**Consultation Response from Mike Hibbert,
KC Waste Strategy(Refuse & Recycling)**

2021/93621 Land off, Fullwood Drive, Golcar, Huddersfield, HD7 4JH

Erection of 12 dwellings and associated works (Within a Conservation Area)

Responding Ref: WPS 23-036

Project No: 2673 Drawing No: (100)03 Rev: 1

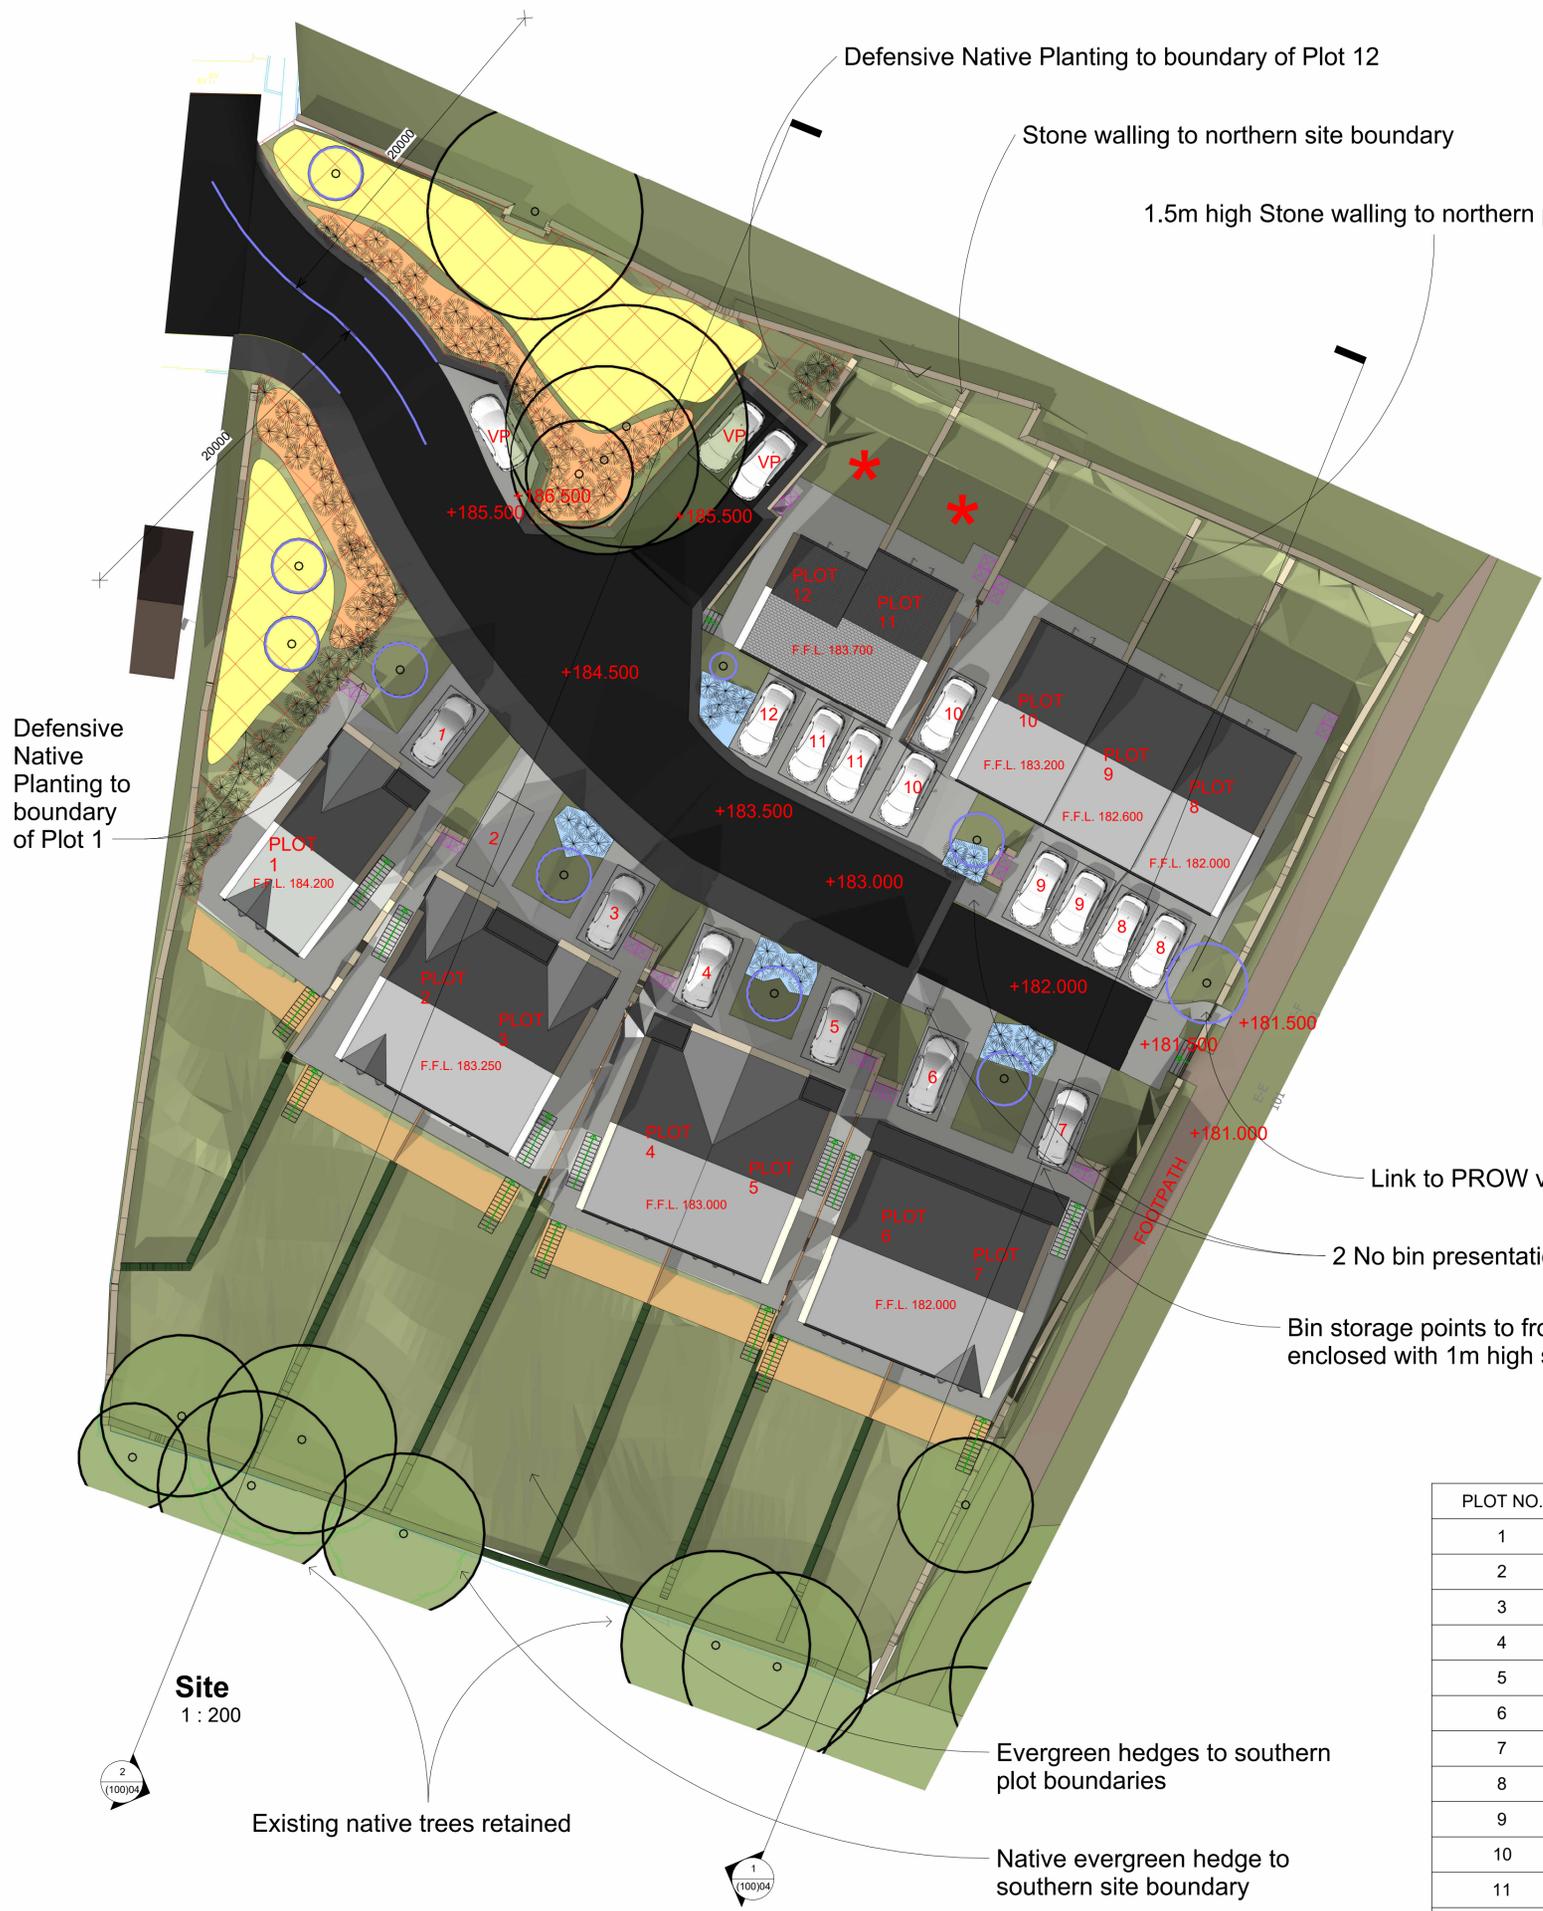
The application is for the erection of 12 dwellings and associated works. The following comments build on previous consultation response ref WPS 23-014 and take account of the revised drawing ADDITION OF BIN COLLECTION & STORAGE POINTS ANNOTATIONS AND F.F.L. Drawing Number (100)03 Rev E dated MAY 23.

- The plan shows each property with storage for two bins. The properties have gardens and therefore storage space should be available to also accommodate a third 240ltrs wheeliebin for garden waste and to reflect potential future changes to waste collection services.

- Preference is given to storage of bins in the rear gardens of properties as is the case with Plots 8 and 10 to 12. Where there is storage of wheeliebins is to the front of properties, due to the topography of the site, it is welcomed that the impact of Streetscene has been reduced by the addition of 1m stone walls to act as screens on Plots No's 1 to 7 and 9.

- The bin storage areas shown at each property are approximately 780mm x 1500mm that is acceptable for 2x 240ltrs wheeliebins but too small to accommodate three bins as required.

- It is welcomed that two Bin Collection Points (BCP's) have been provided for plots 6 to 9. The BCP is large enough for the number of bins being presented.

- Suitable site access and manoeuvrability space for a Refuse Collection Vehicle is vital to the Council's ability to discharge its obligation to collect waste from domestic properties. This obligation will exist in perpetuity on any residential development and as such will be a critical consideration in the layout of the site if approval is granted. Confirmation is required that the turning head for the properties at the Northwest end of the access road adjacent to Plot 12 is of an appropriate size.

- Where turning is necessary, the turning facilities must be demonstrably sufficient for an 11.22m refuse collection vehicle and opportunities for parking in the turning area must be designed out. Swept path analysis must show the manoeuvrability of this vehicle throughout the site, demonstrating the safe passing of other vehicles likely to be using the road – either parked or moving.

- Visitor parking is shown on the layout plan next to the turning head. Parked cars are a perpetual problem for RCV access and as such it is important to account for potential parking spaces, even where these are undefined when assessing RCV access around the site. Active measures should be adopted to prevent parking in the turning head as this would not be visible when the RCV enters the development and if blocked would require an RCV to undertake a long reversing manoeuvre that is a recognised safety risk.
